From: Sue Howell
Sent: 07 September 2017 16:22
To: Simon Davis
Subject: RE: Planning Consultation on: Y/40/17/OUT

Further to reconsideration of these proposals I would want to reiterate my comments of 09/08/2017 and to confirm my objection on Landscape and amenity grounds to the proposals put forward in application Y/40/17/OUT. Whilst there are recommended calculations for offsite play provision which can be calculated at approx. £1560.00/dwelling (SPG October 2000 index linked) there is no satisfactory substitution for lack of Public Open Space.

APPLICATION Y/40/17/OUT

Description of Works: Outline application with some matters reserved
(access only) - erection of 34No. dwellings with
access from Hoe Lane, Flansham. This
application affects the setting of a Listed Building.
This application is a Departure from the
Development Plan.

1. EXPLANATORY SHEETS, TREE INSPECTION SHEETS
2. TREE CONSTRAINTS PLAN, DRAWING NO. J53.95/01 Rev. A
3. TABLE OF BS CALCULATED ROOT PROTECTION AREAS (RPAs)

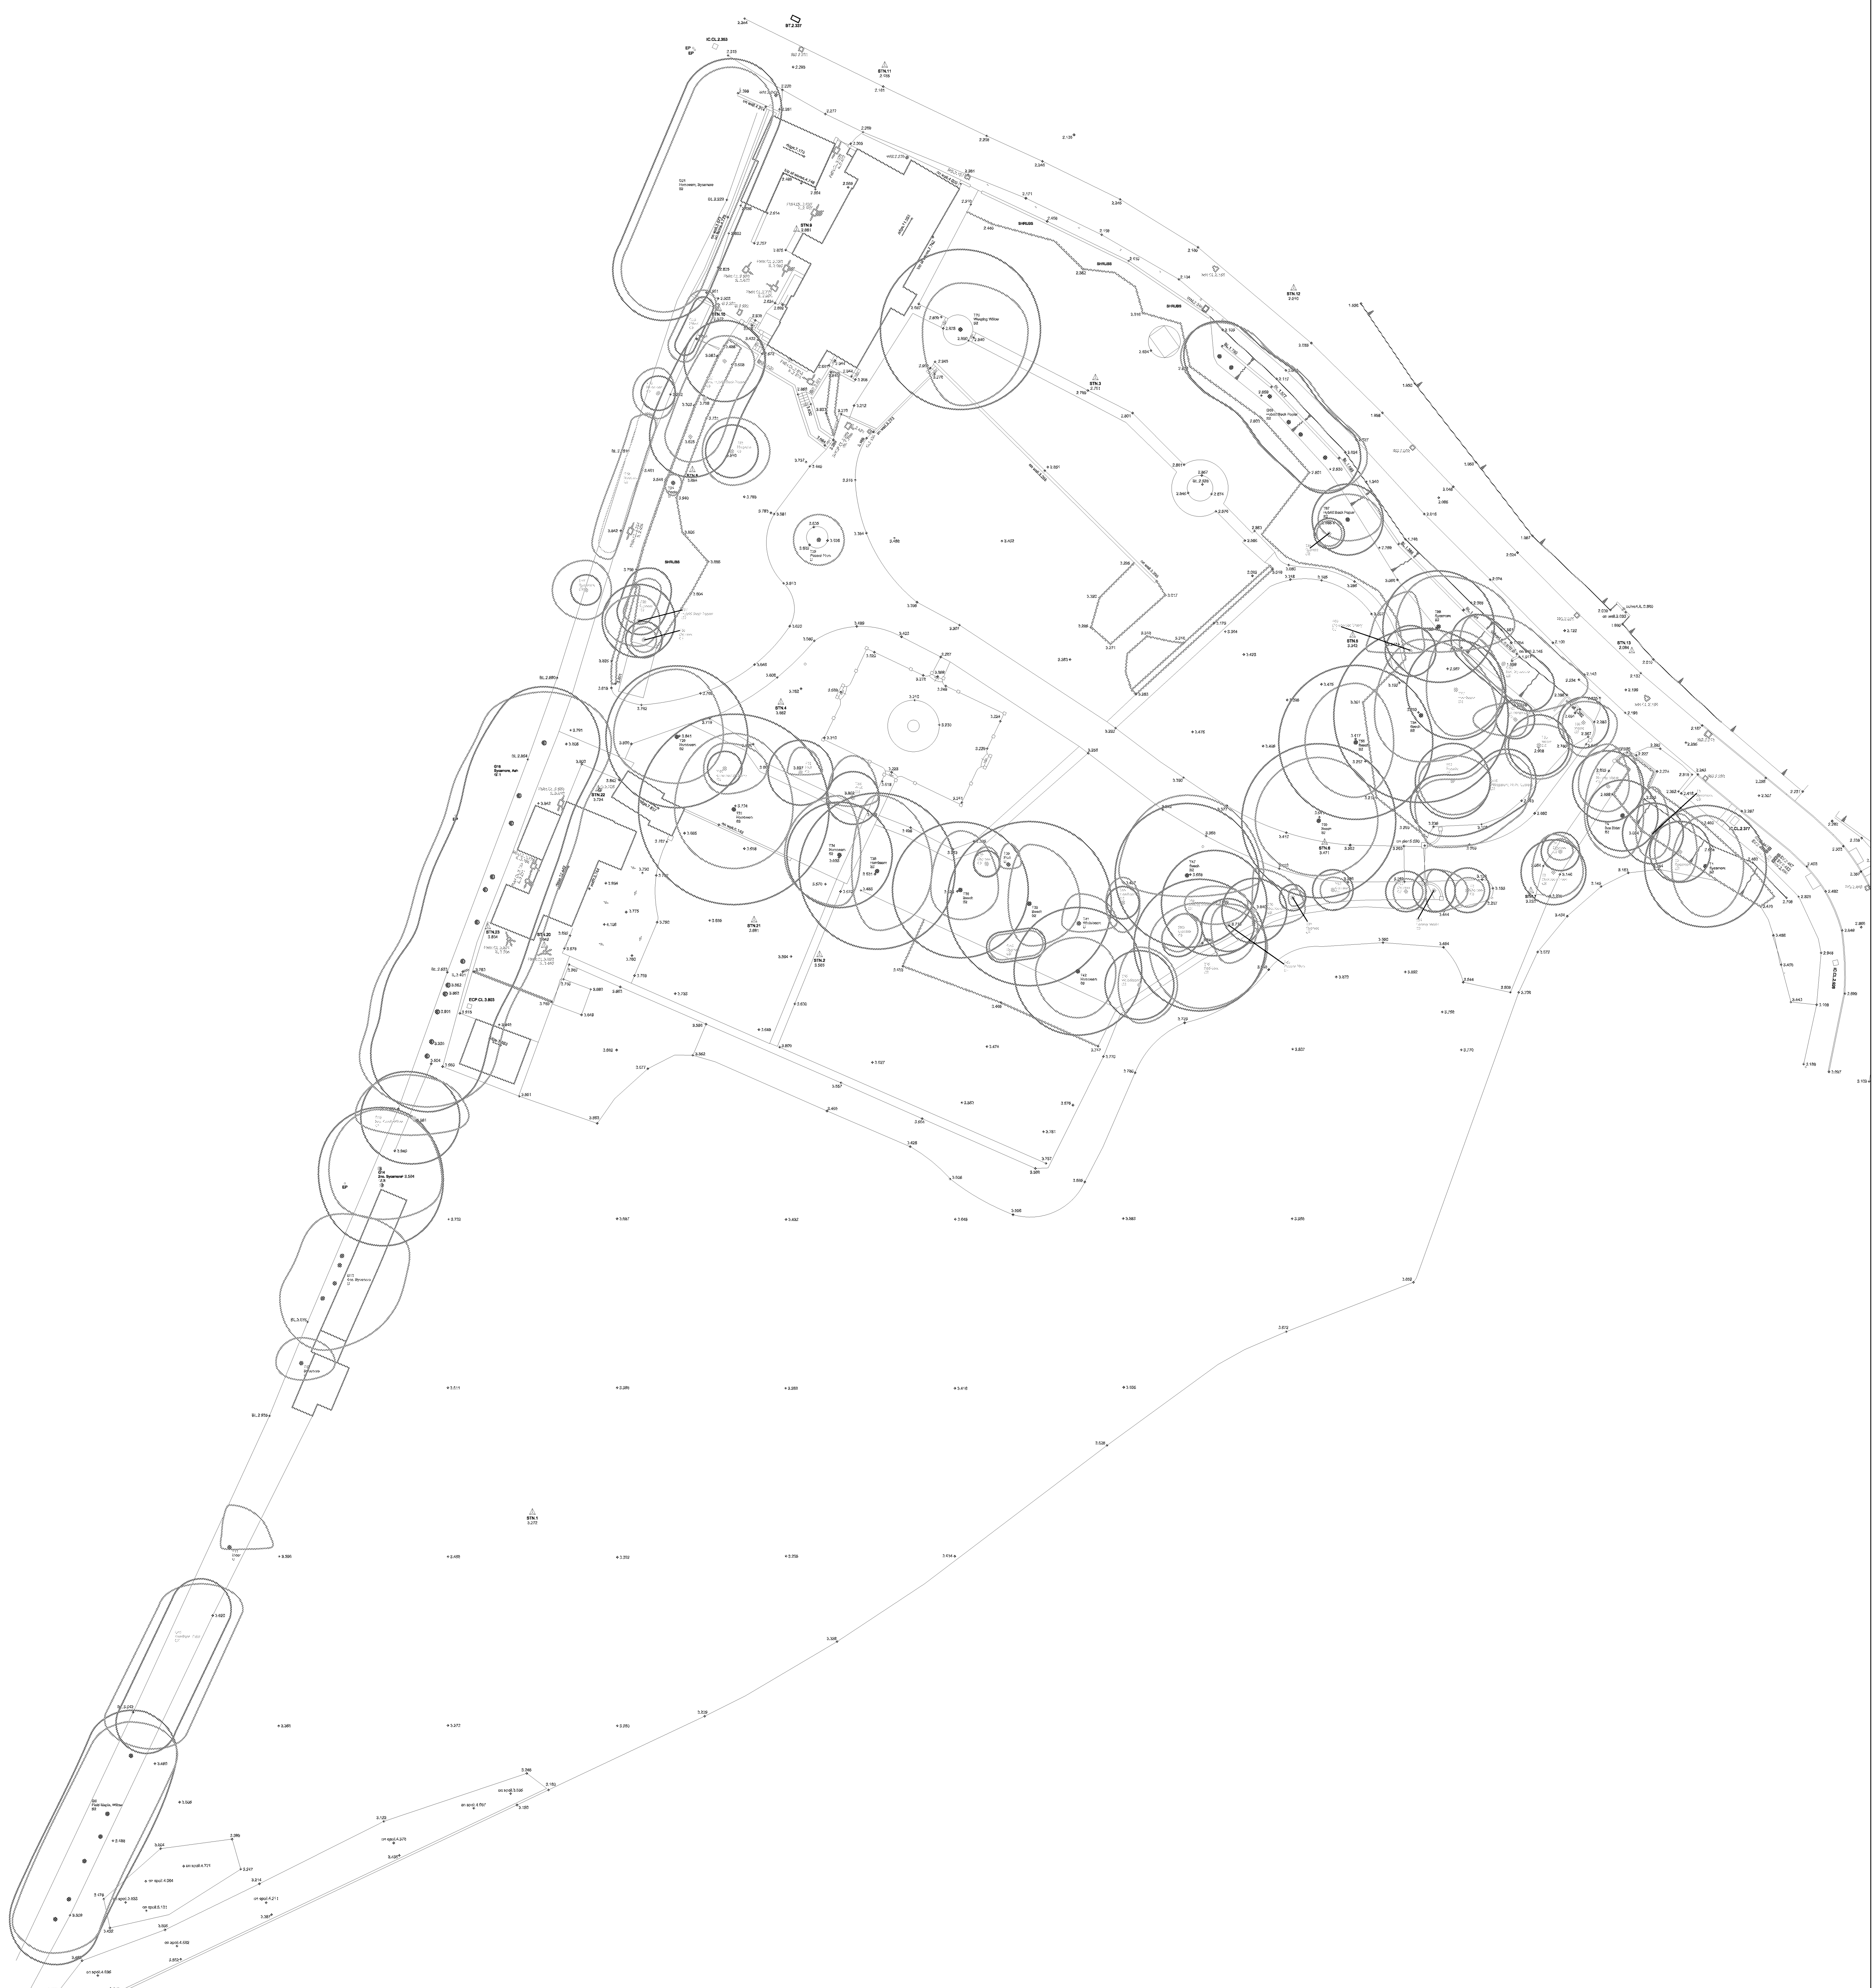
A tree survey relating to existing trees would need to be undertaken. Tree protection fencing requirements identified and tree protection plans submitted which would need to be conditioned with any permission.

Any significant existing trees clearly those evident within the centre of the development proposal, must be protected during the works and given the space to be allowed to mature fully. Any trees that have the potential for a long life expectancy, with potential to become a prominent feature within the landscape and are worthy of protection, with adequate fencing according to the BS 5837 (2012) Provision for fencing according to each of the trees' correct and calculated root protection area must be erected prior to the commencement of any development activities.

Appendix A Architects Layout GA

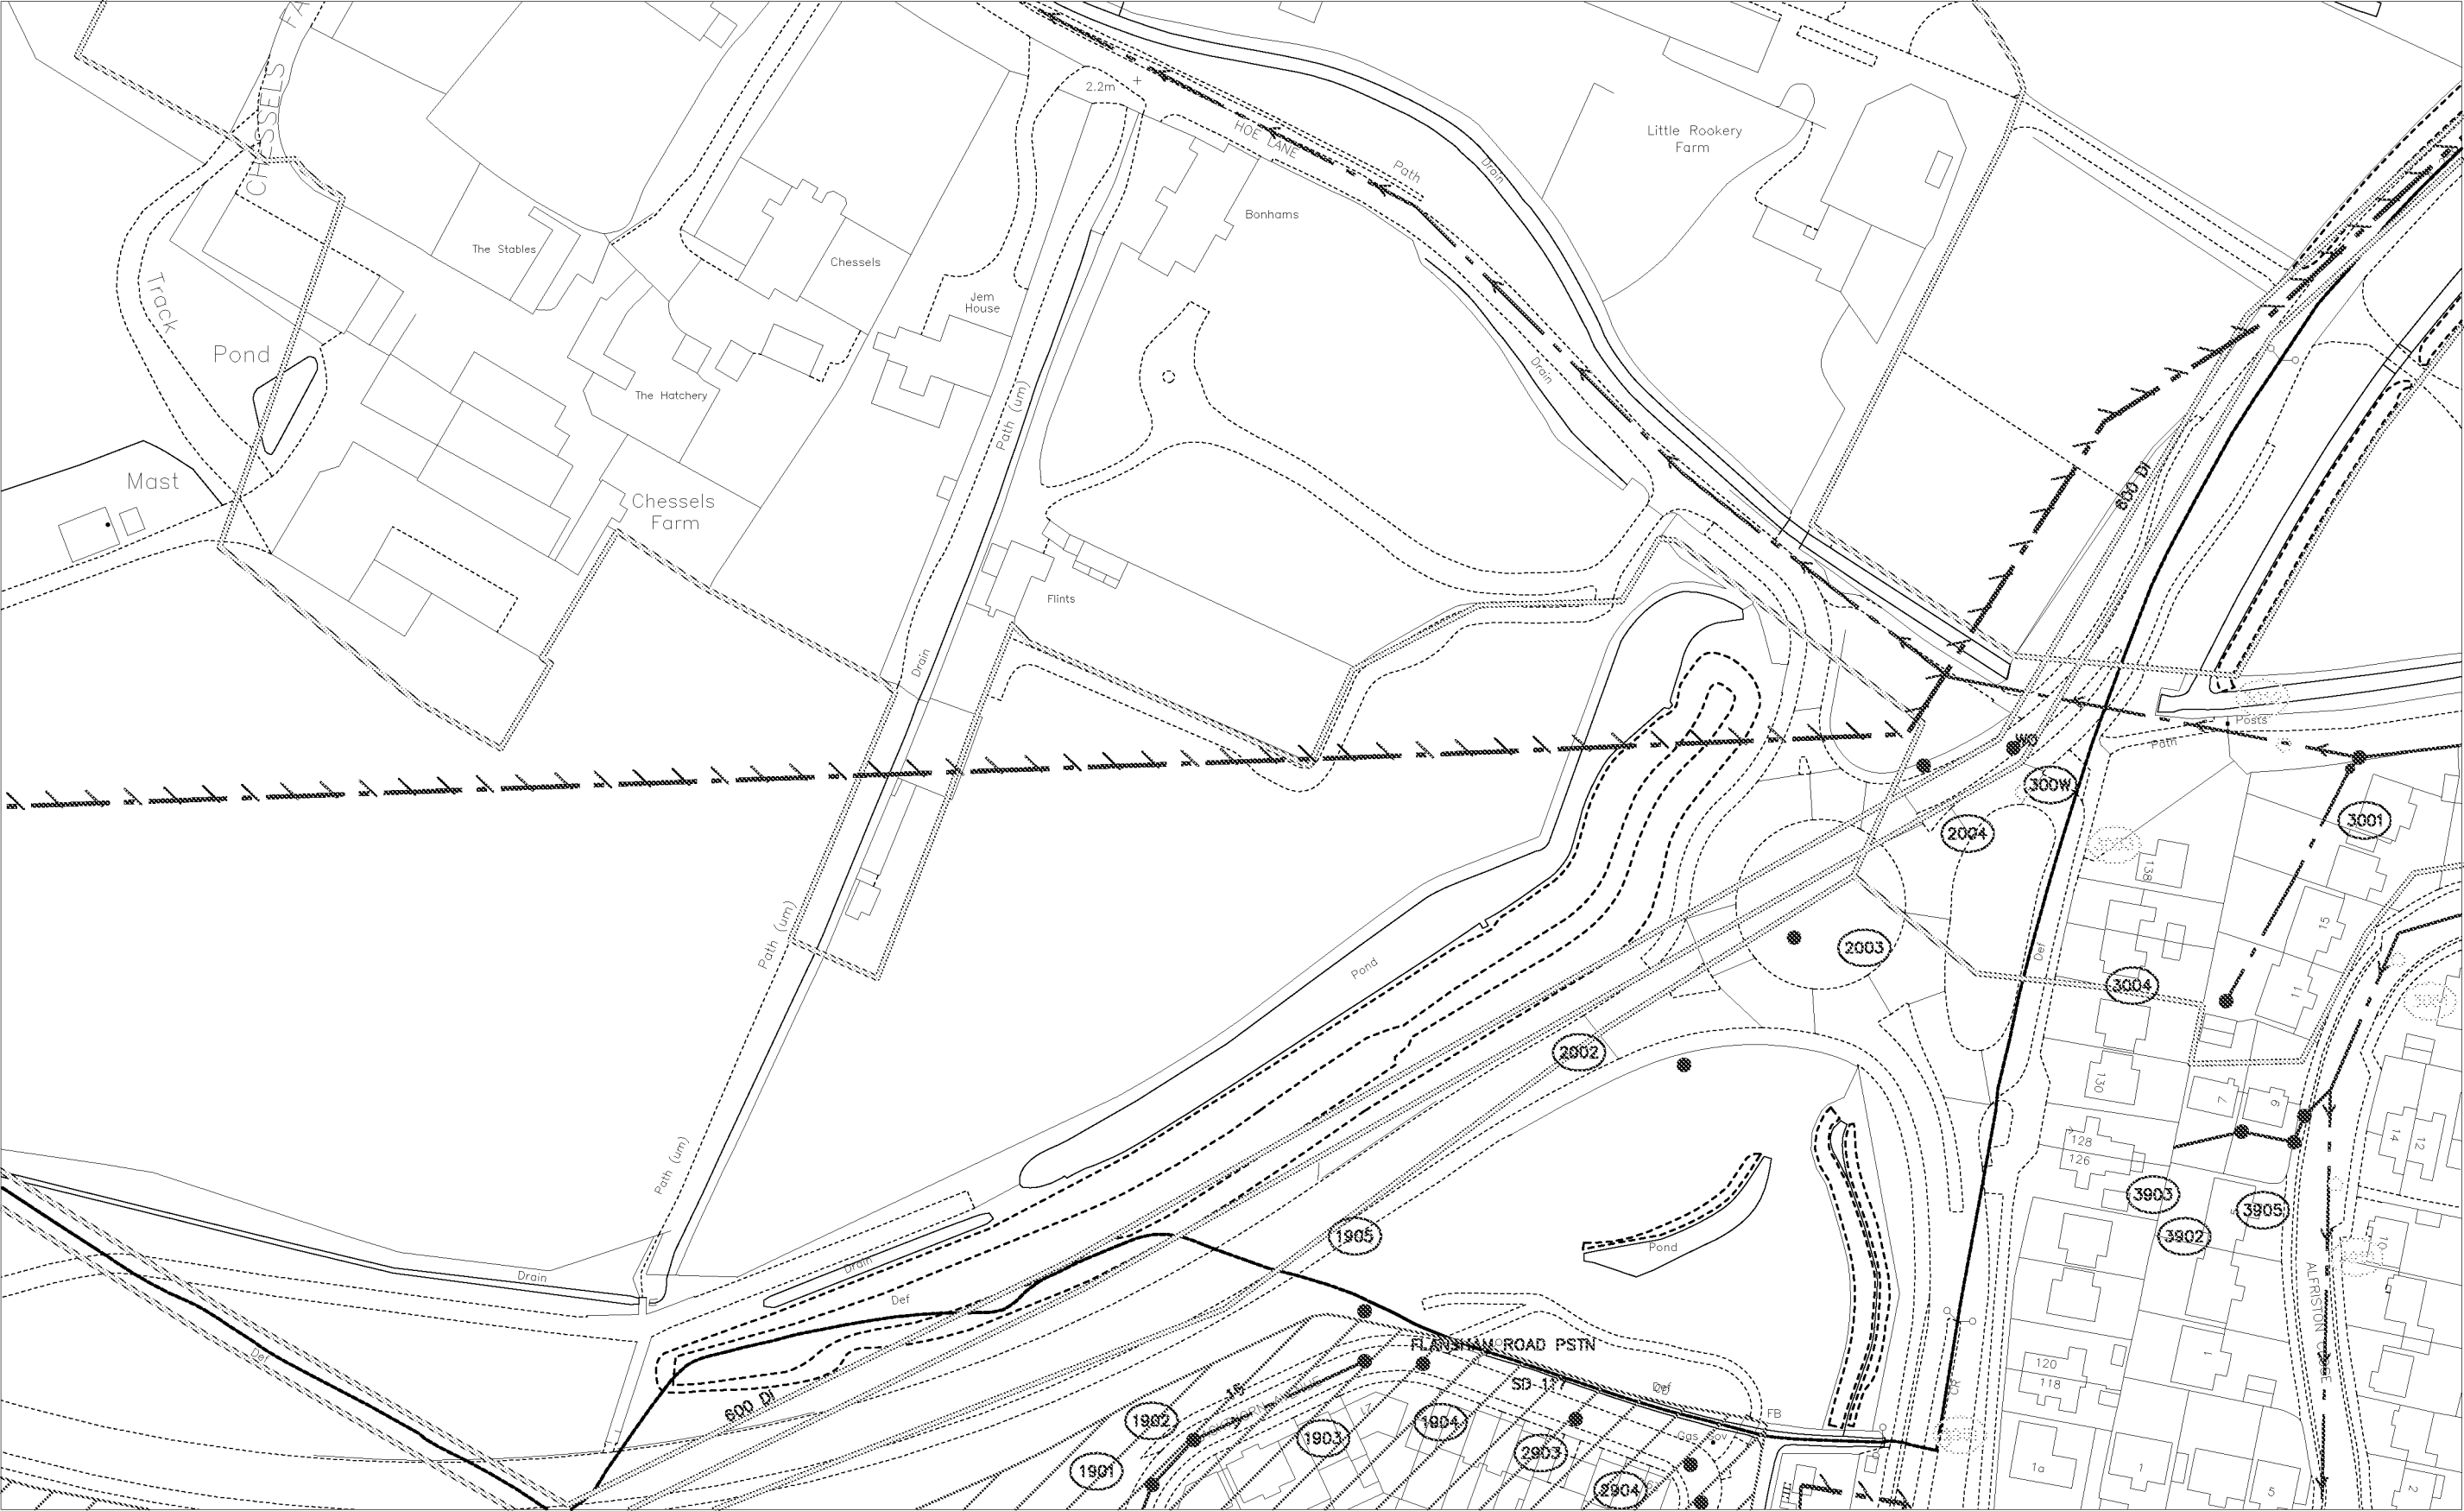
The proposed indicative layout shows two small areas of open space which would appear to be pretty unusable with no connectivity to the wider surrounds and no play consideration indicated. There does not appear to have been any consideration of the existing significant trees and to the incorporation of these into any open space areas. The existing trees have been indicated as proposed to be within the garden confines of several of the proposed houses which would have the potential to be problematic and not offer long-term protection going forward. The whole nature of this proposed site would be dramatically changed with a layout that appears to be hugely over developed.

I would recommend that the Public Open Spaces and their connection with the proposed development are reconsidered and that all of the above points are agreed or conditioned with any decision.
